**TOWER 2, LEVEL 23
DARLING PARK, 201 SUSSEX ST
SYDNEY NSW 2000**

17 November 2016

S75W (2) AMENDMENT TO MP10_0016 - SCOTTISH HOSPITAL, PADDINGTON

DRAWING TITLE:  
**LEVEL 09 - ROOF PLAN - BROWN STREET BUILDING**

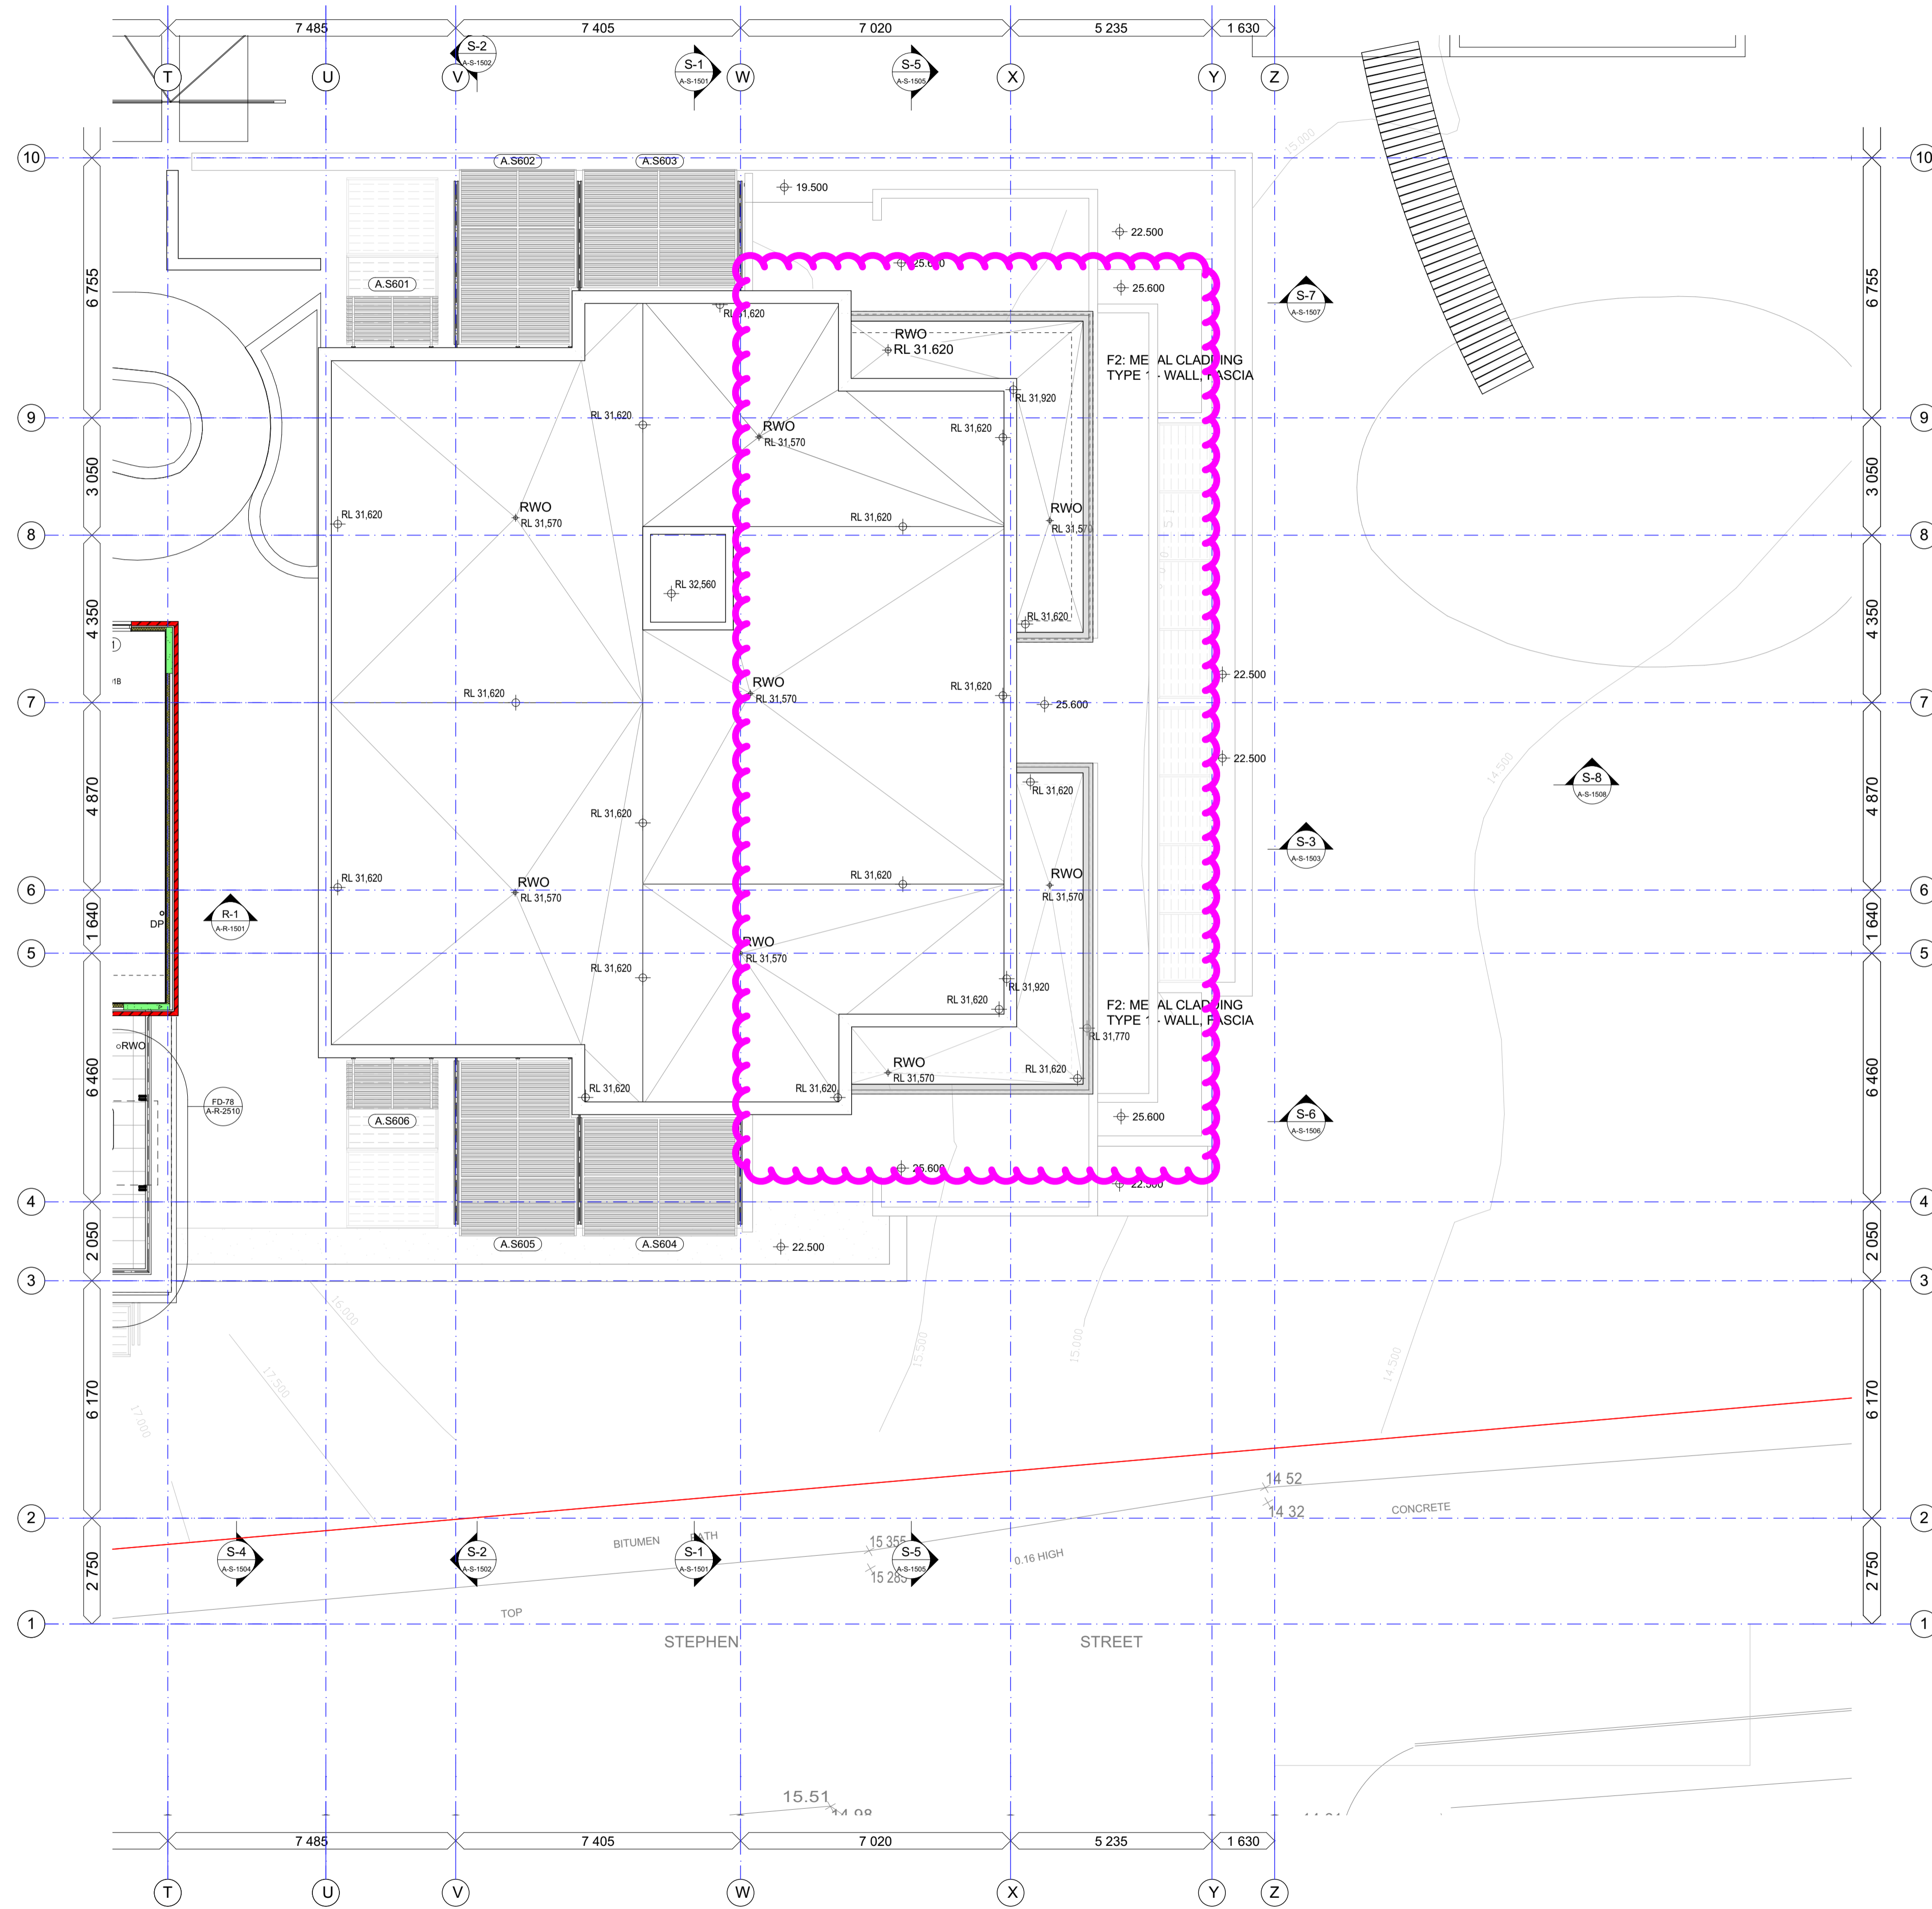
The Department sought further details of the metal clad fascia to the concrete roofs, including a 1:20 Section Plan through Brown Street Independent Living Unit and the Stephen Street Residential Aged Care Facility building to ensure appropriate detailing of this junction.

DRAWING TITLE:  
**WEST ELEVATION - BROWN STREET**

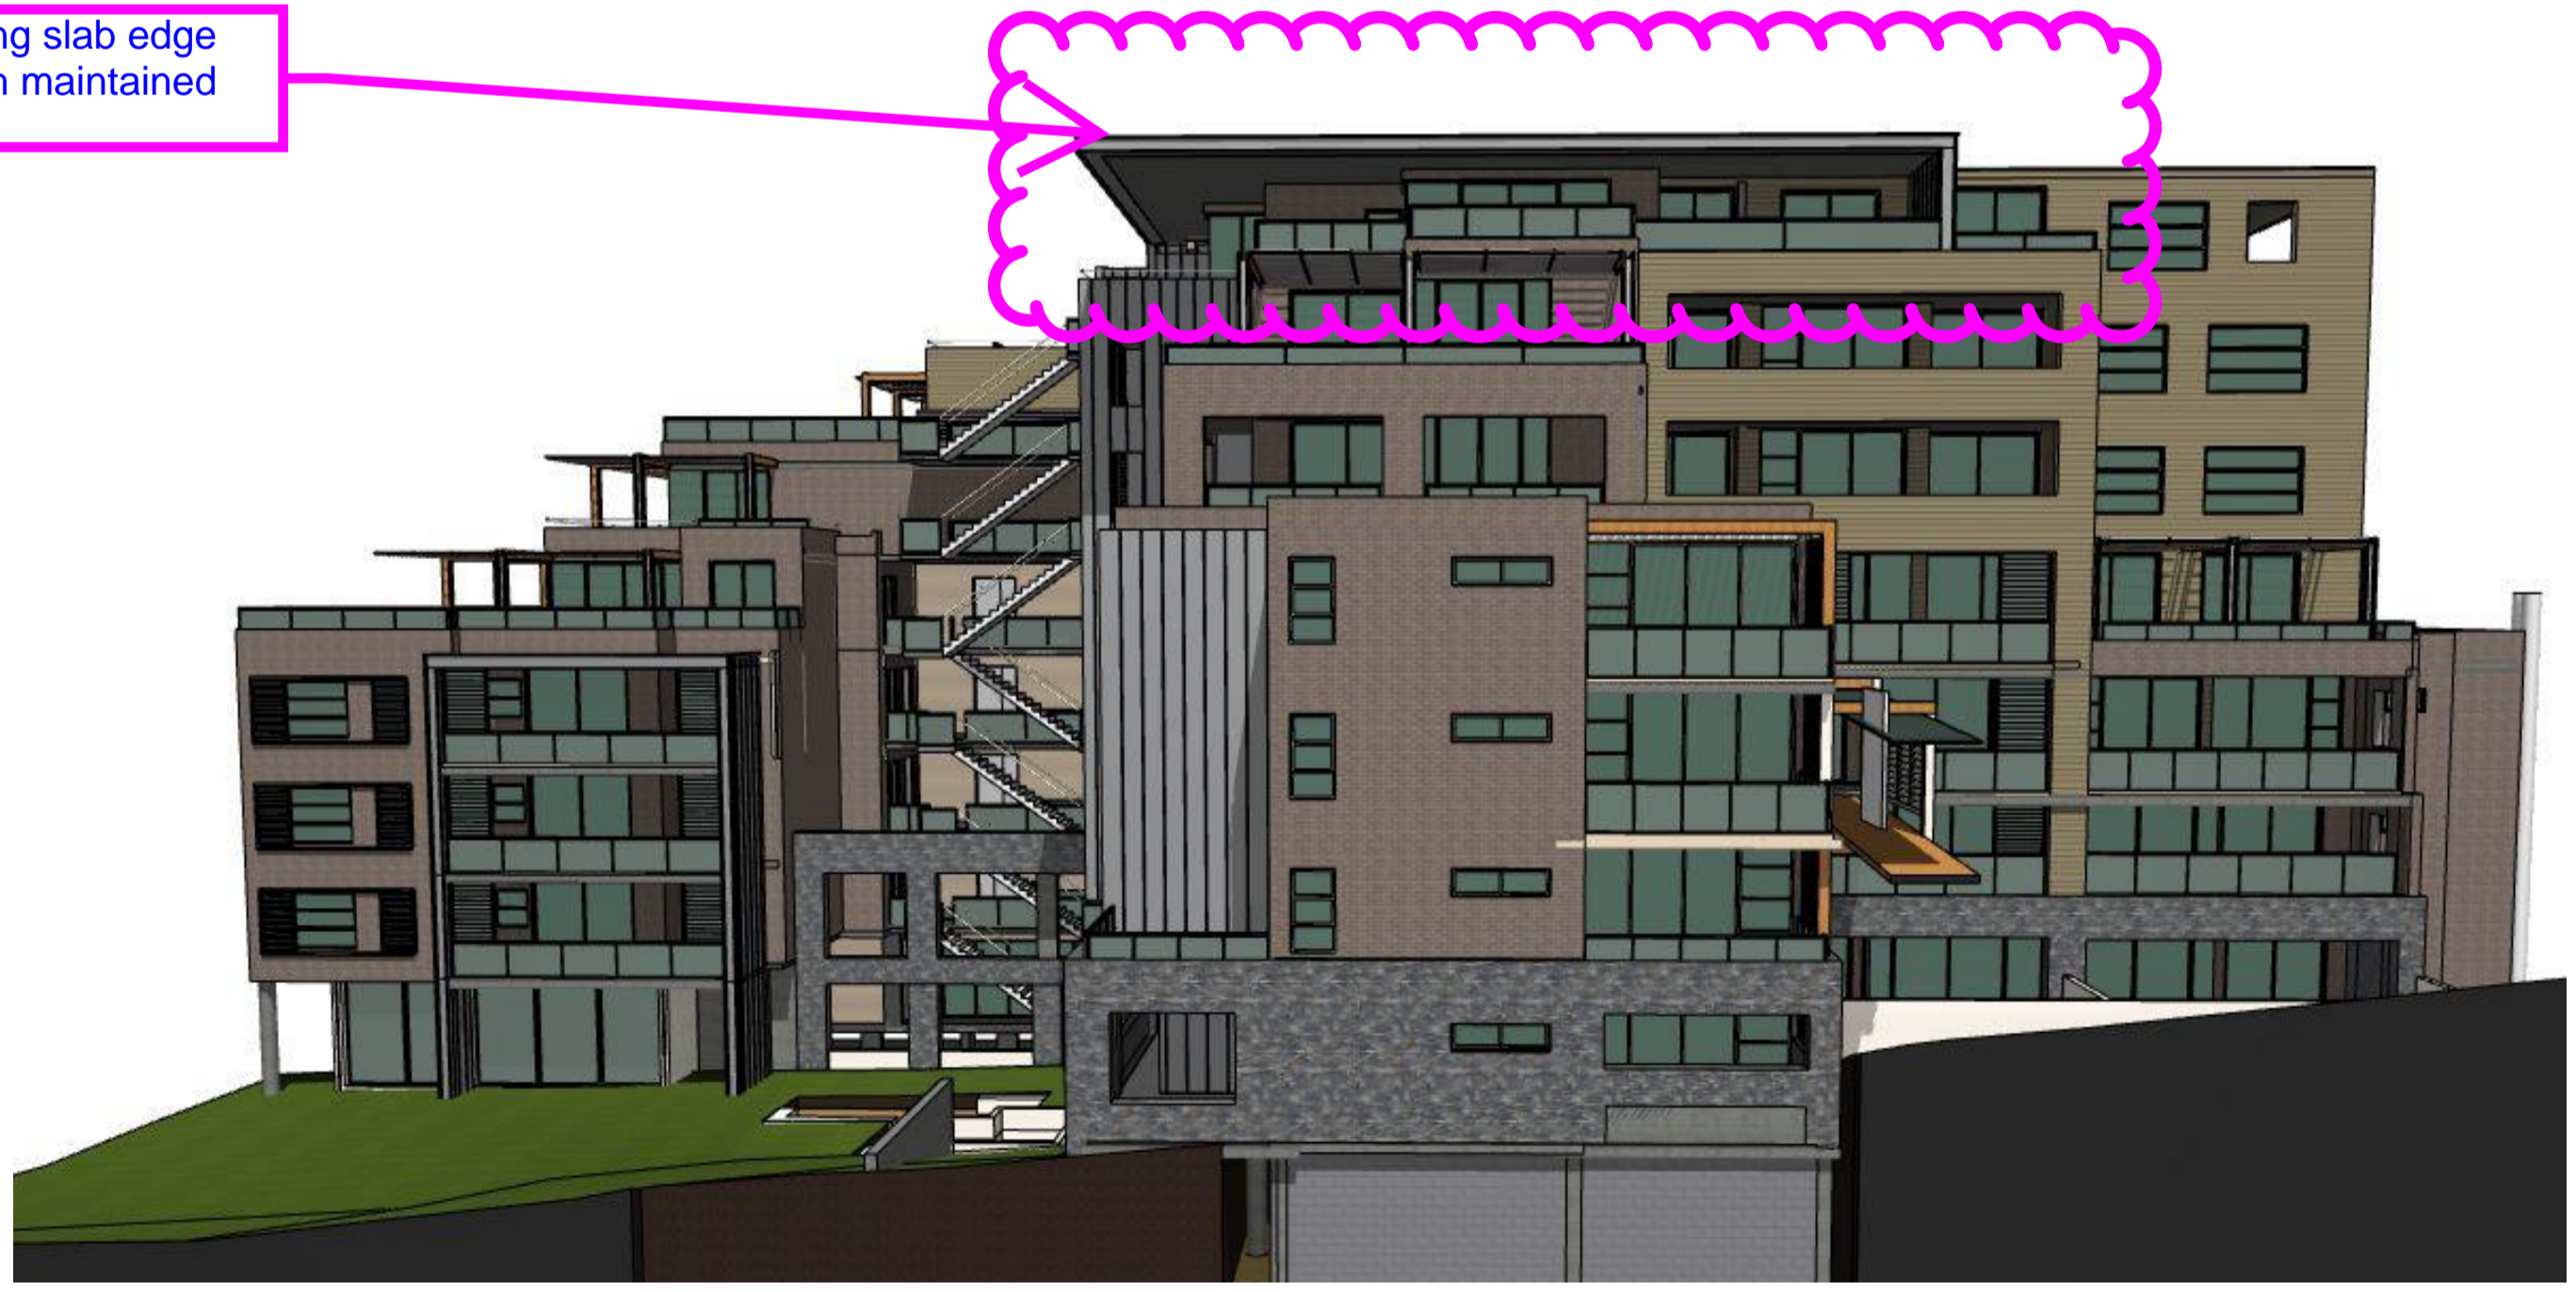
The Department sought additional drawings showing details of the clerestory windows proposed for deletion and the views of the proposed photovoltaic panels from the surrounding public domain.

- West Elevation Brown Street Plan 'Current Status' Ref: 2014063 A-X-B-1528 Rev AA (dated 20/10/16);

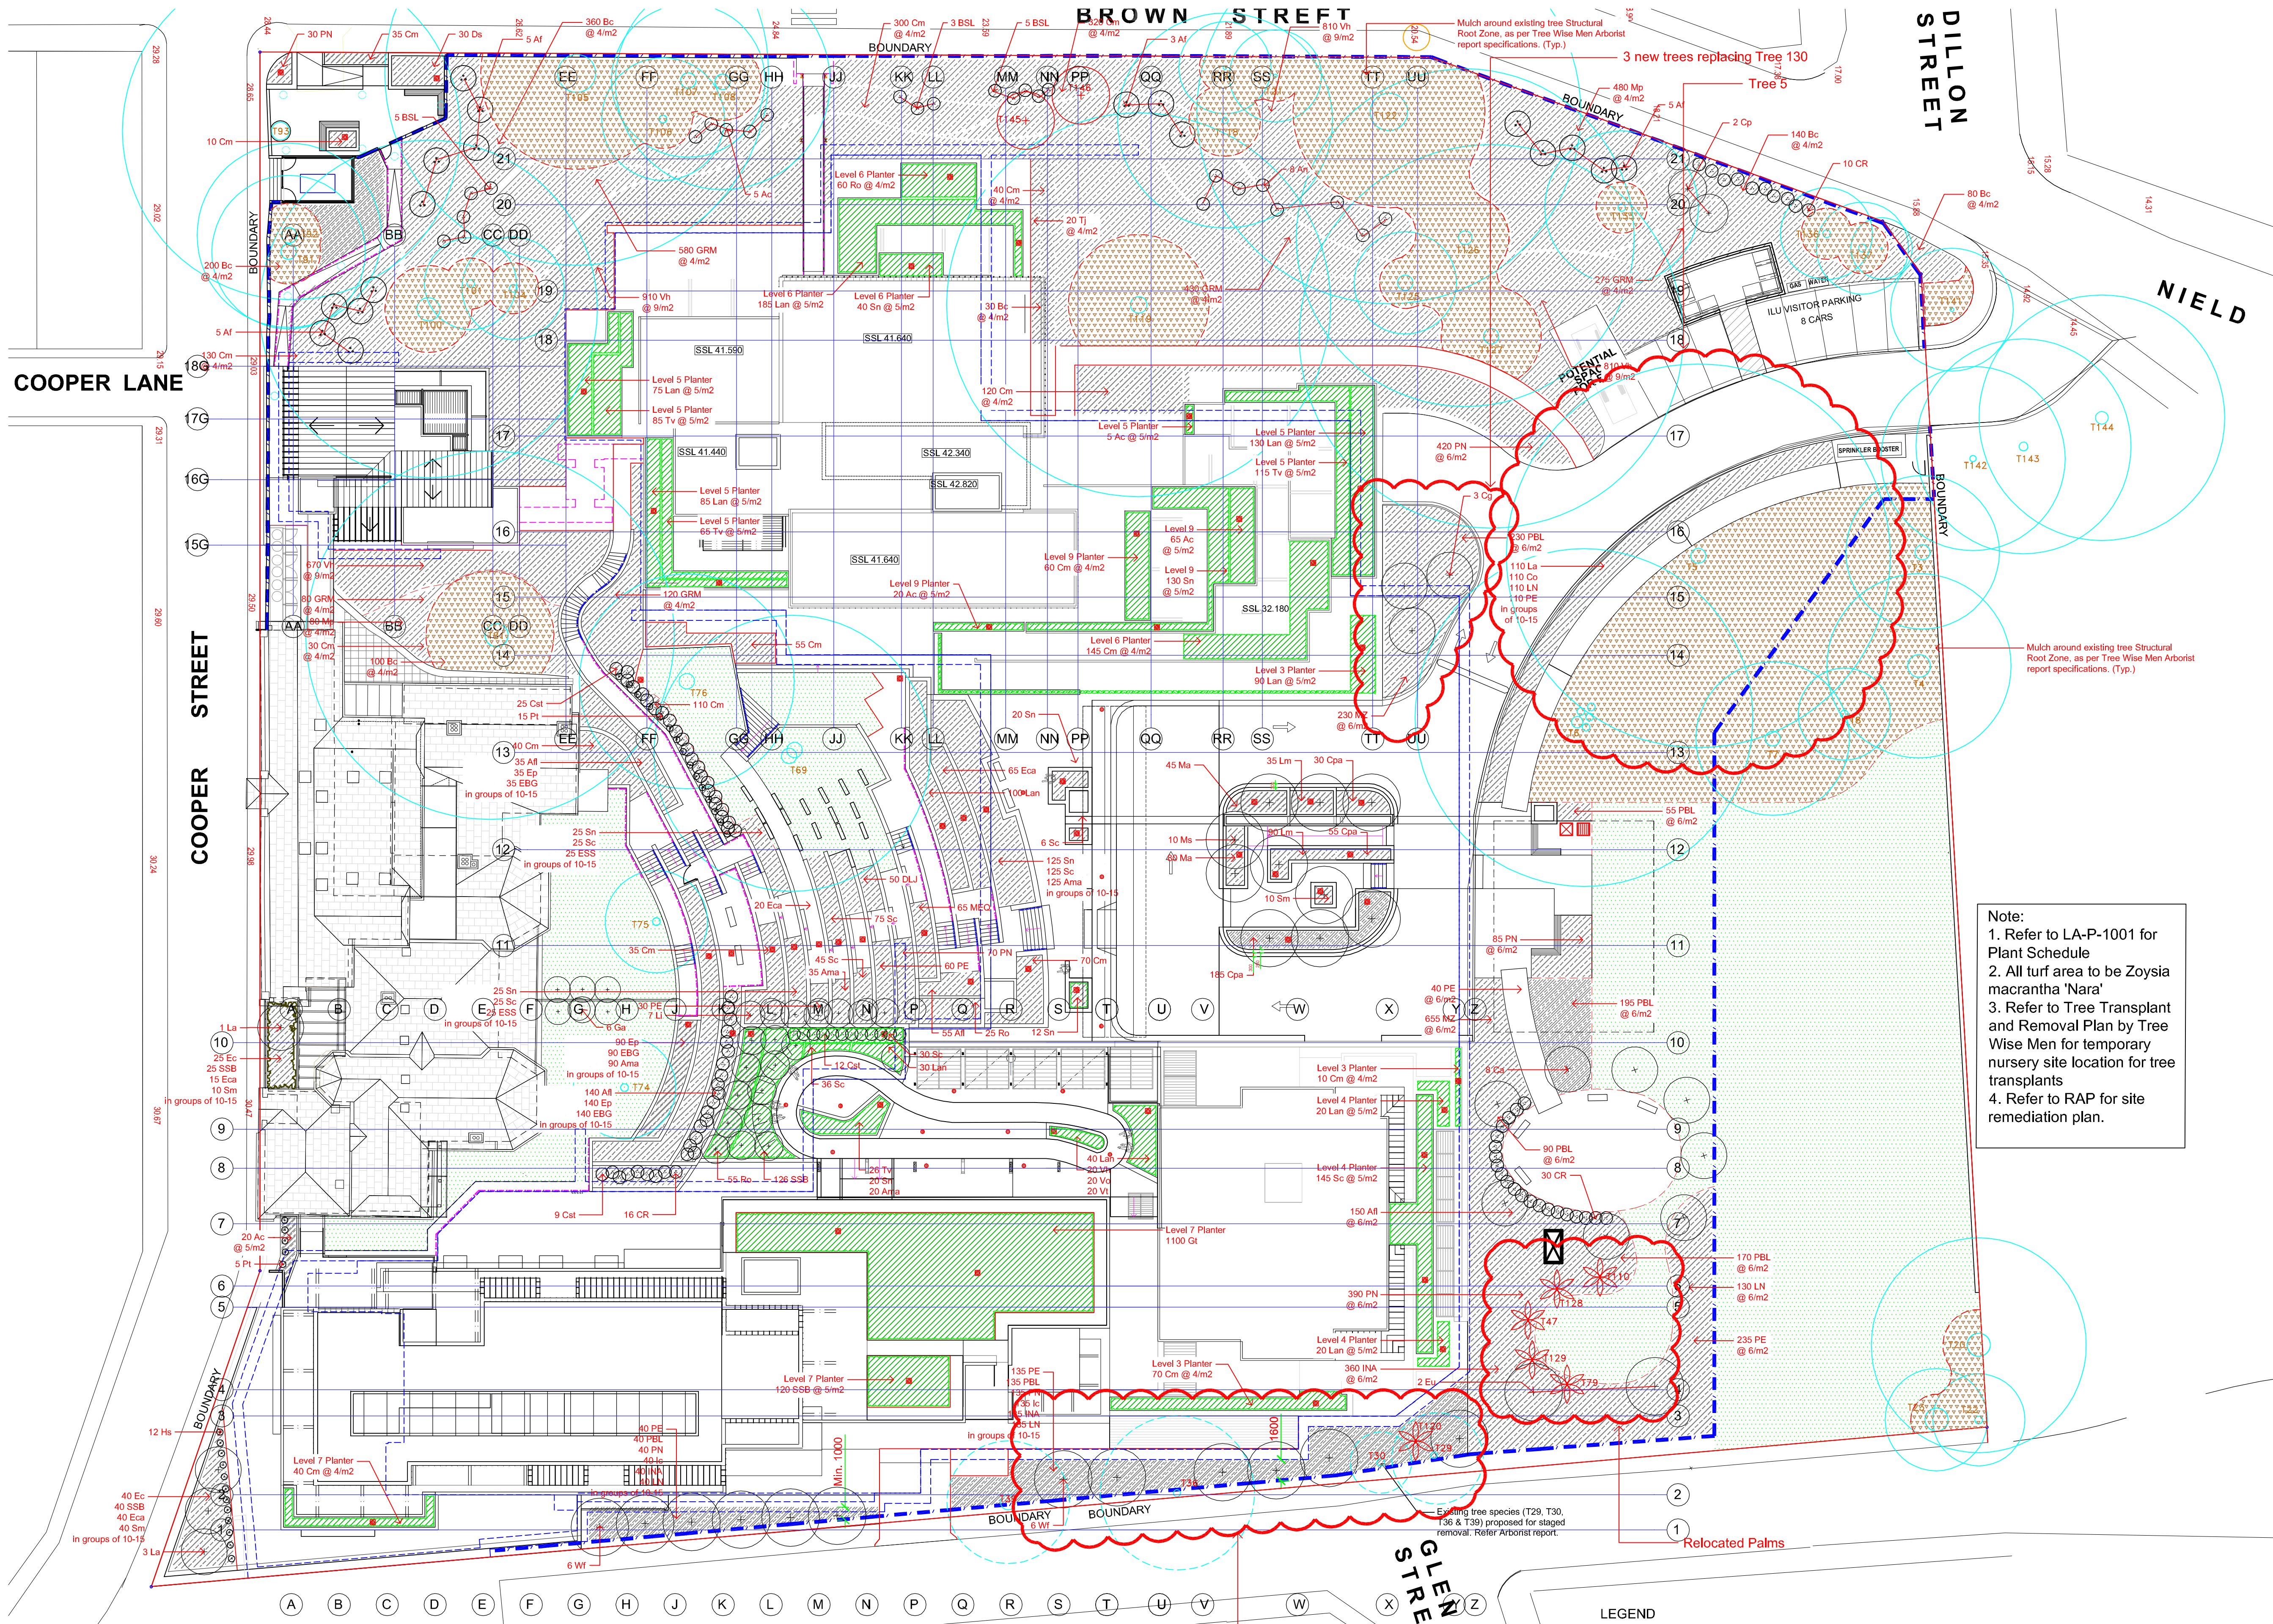
The Department requested further justification to support the removal of trees No. 5 and 130, including further consideration of alternative options for construction work that could facilitate the retention of these trees. If the trees need to be replaced following consideration, justification is required to support the replacement including the consideration of alternative options that better reflect the size and species of the existing trees.

In short, Tree No. 130 is required to be replaced, given that the original root zone impact assessment contained an error meaning that the trunk centre was misinterpreted. This means that excavation works would now significantly encroach into the structural root zone, which would destabilise the tree. Furthermore, from a foliage perspective, the impact of removing Tree No.130 would be limited in terms of views from outside the site. This is because there is heavy tree cover on the Brown Street frontage, which largely screens the tree from on-street views. Given this situation, it is preferable for Tree No.130 to be removed and replaced in a more suitable location with a large Smooth Barked Apple Tree which can contribute significantly to the surroundings.

With regard to Tree No.5, its removal would benefit a range of other trees on the site, including the significant heritage listed Tree No.6. The visual impact of removing this tree would also be negligible due to its boundary set back and the location of other retained trees. New replacement planting can be added to mitigate this loss, which includes the planting of a super-advanced Port Jackson Fig.
